Rezoning Transportation Analysis

Petition Number: 2022-146

Date	Description
1-25-23	First Review (IW)

**CORNERSTONE\_TOWNHOMES**  
CHARLOTTE, NC  
Project: CORNERSTONE\_TOWNHOMES  
Sheet Title: REZONING PLAN

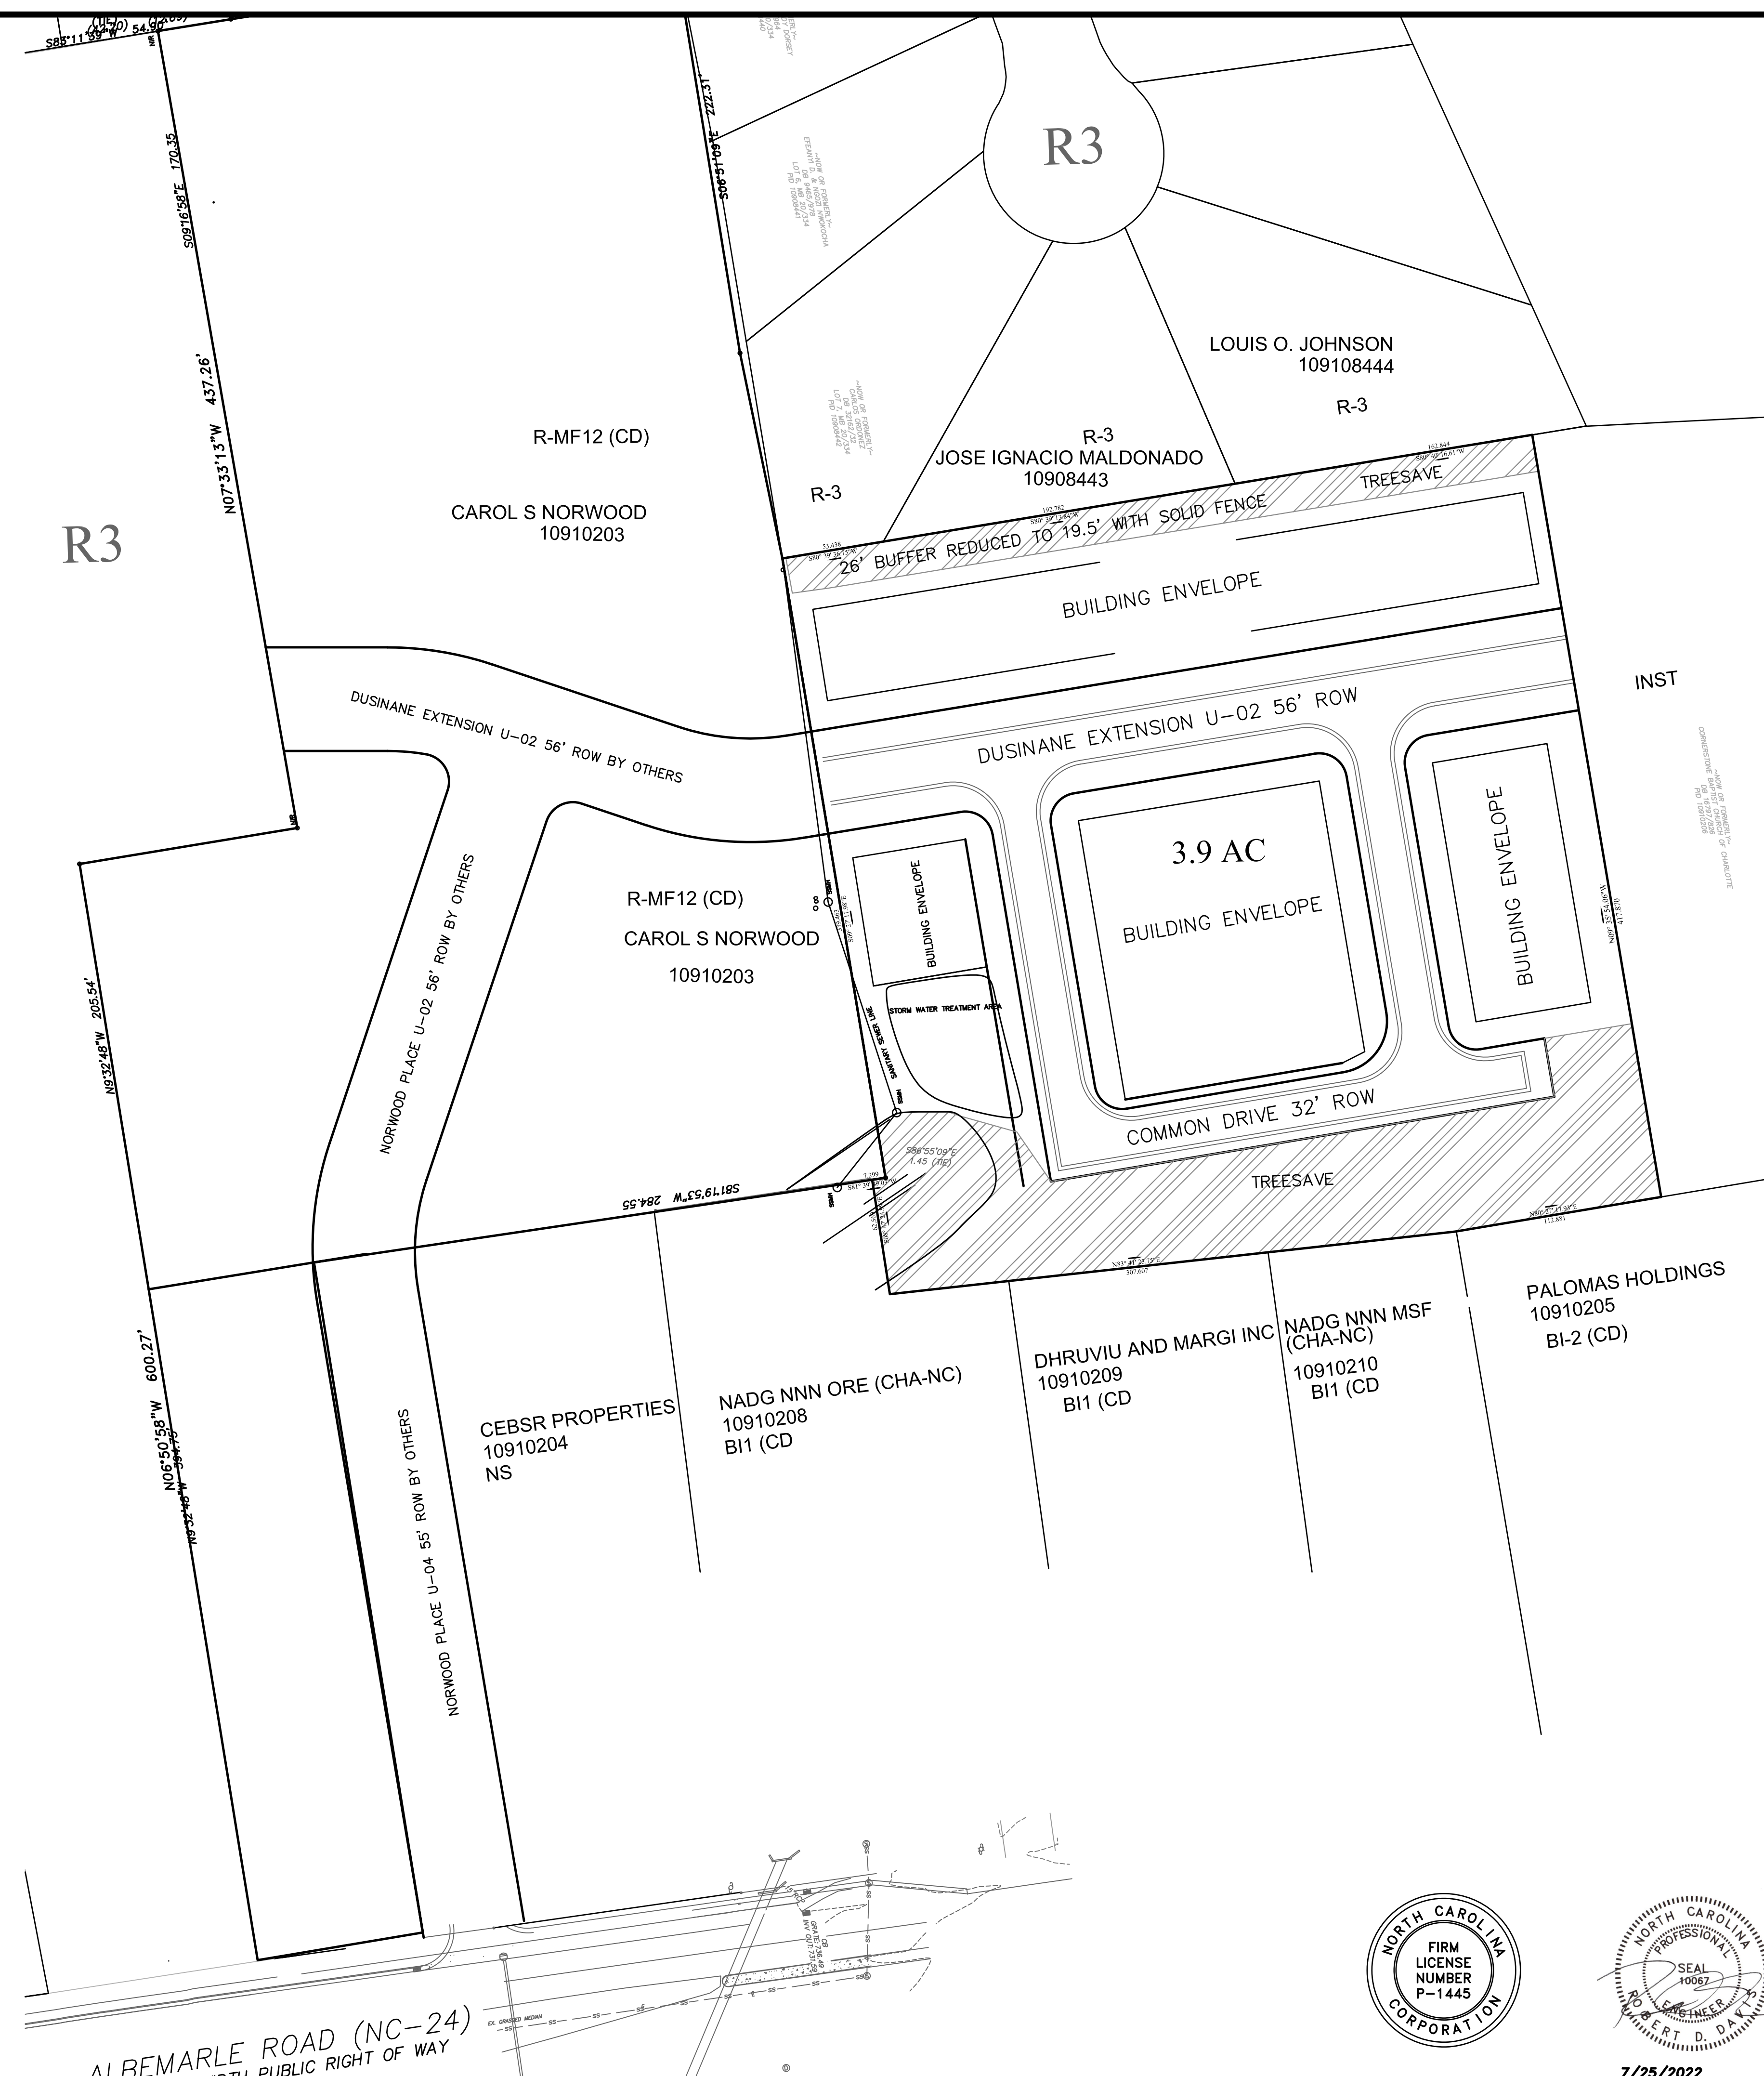
1. Curblines:

- a. **Dusinane Extension:** Location of curb and gutter to be set appropriately once street is constructed by separate developer.

NOTE: Additional distance from center line to back of curb may be required in locations where a median is present or around intersections and interchanges.

Label and dimension the curb and gutter from the centerline for each road on the site plan.

- 3. Revise site plan and conditional note(s) to commit to construct an 8-foot planting strip, and 5-foot sidewalk on Dusinane Extension per Chapter 20. The site plan shall label and dimension both items from the back of curb and gutter or edge of pavement.
- 4. Revise site plan to remove public right-of-way designation for private streets as shown below. Label and provide CLDSM designation for proposed private streets.
